Application by Mona Offshore Wind Limited for an Order Granting Development Consent for the Mona Offshore Wind Farm (Case Ref: EN10137)

**John Tudur Owen & Gwenllian Humphreys Owen – Nant Fawr, Y Nentydd, Rhyd-y-Foel. LL22 8EF
P Ref – 20048466**

Deadline 3 – Response to ExQ1

Figure 1-27: Evening/weekend construction noise impact magnitudes: Substation access road and car parking works

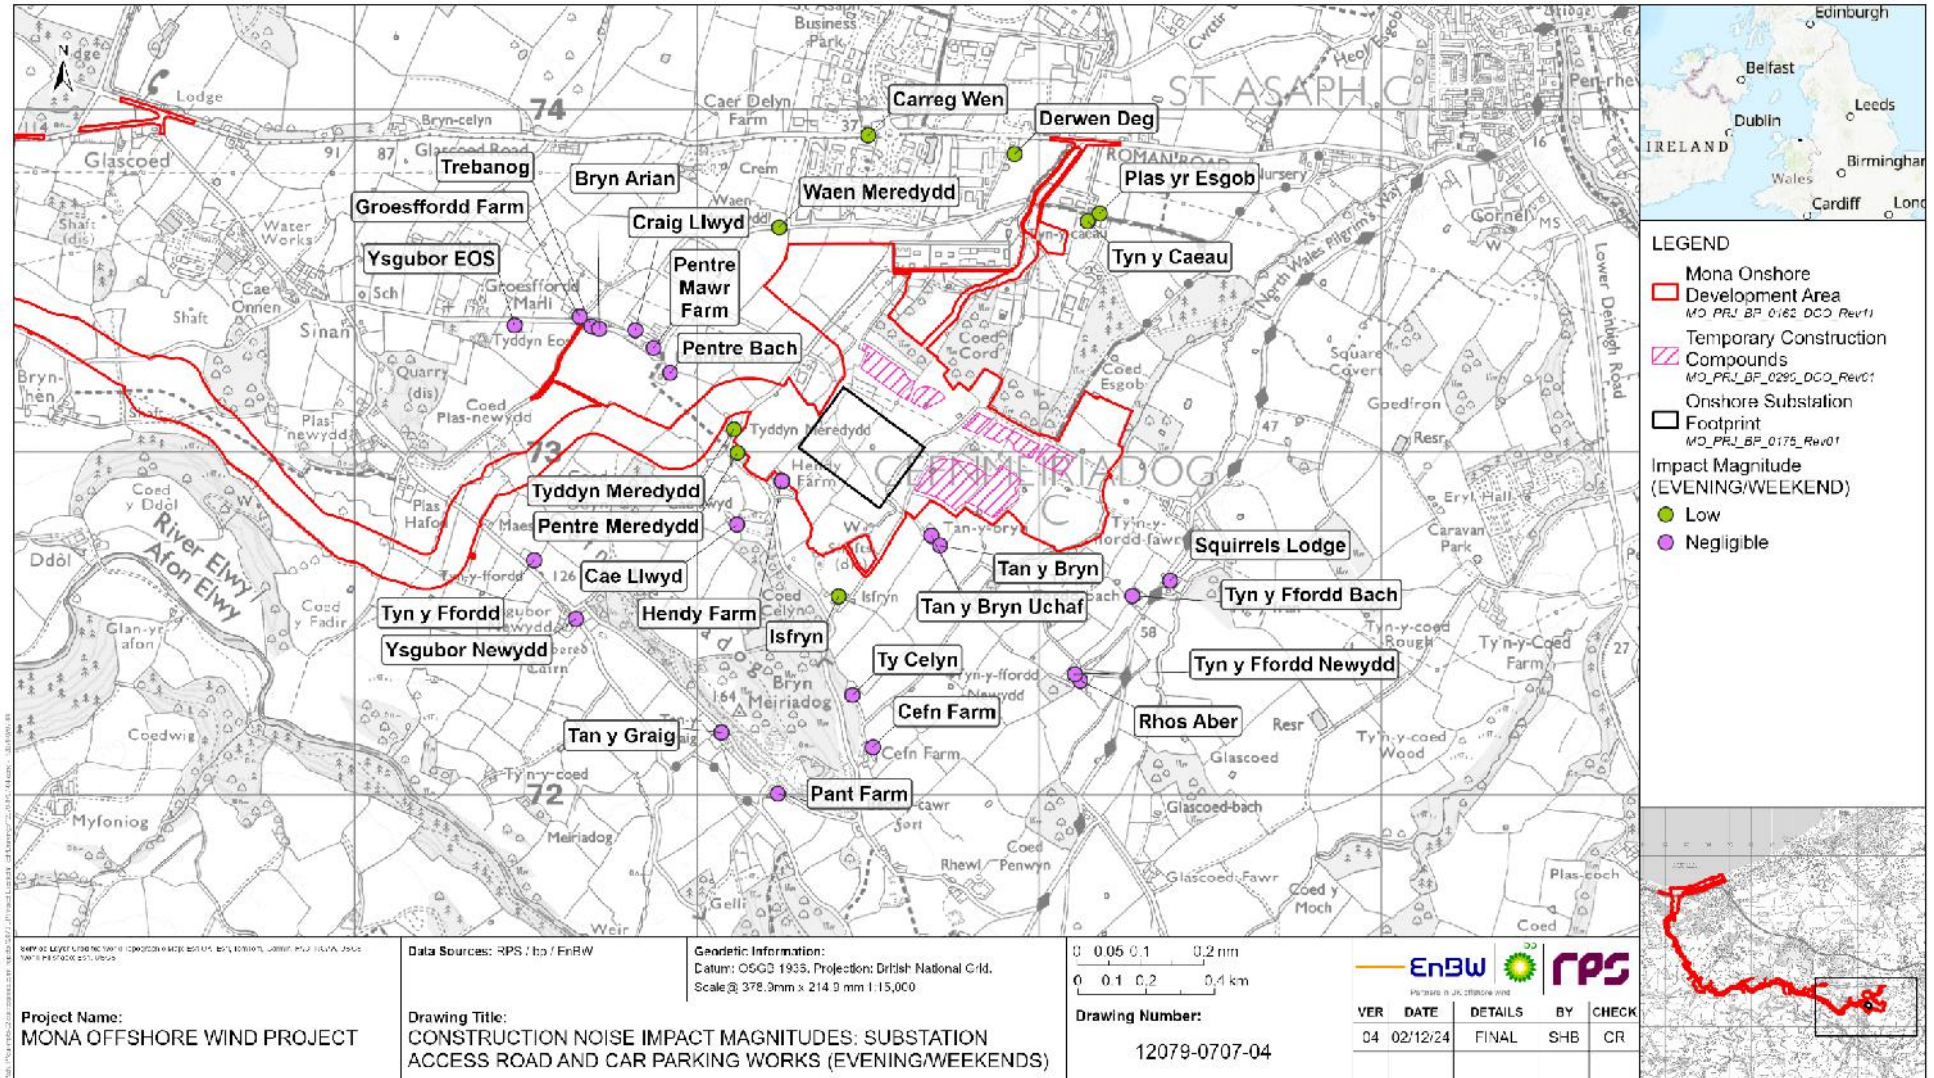
The Outline Construction Noise and Vibration Management Plan does not provide sufficient information on mitigation at Nant Fawr. Figures 1.27 to 1.34 of the Environmental Statement - Volume 7, Annex 9.2: Construction Noise and Vibration Technical Report clearly illustrates that there will be a significant impact at Nant Fawr.

It is requested that the project undertakes further engagement with Mr and Mrs Owen to:

- Provide details and assurances of the construction methods, timings and mitigation measures to be implemented proximate to Nant Fawr for the benefit and protection of the property and its inhabitants.
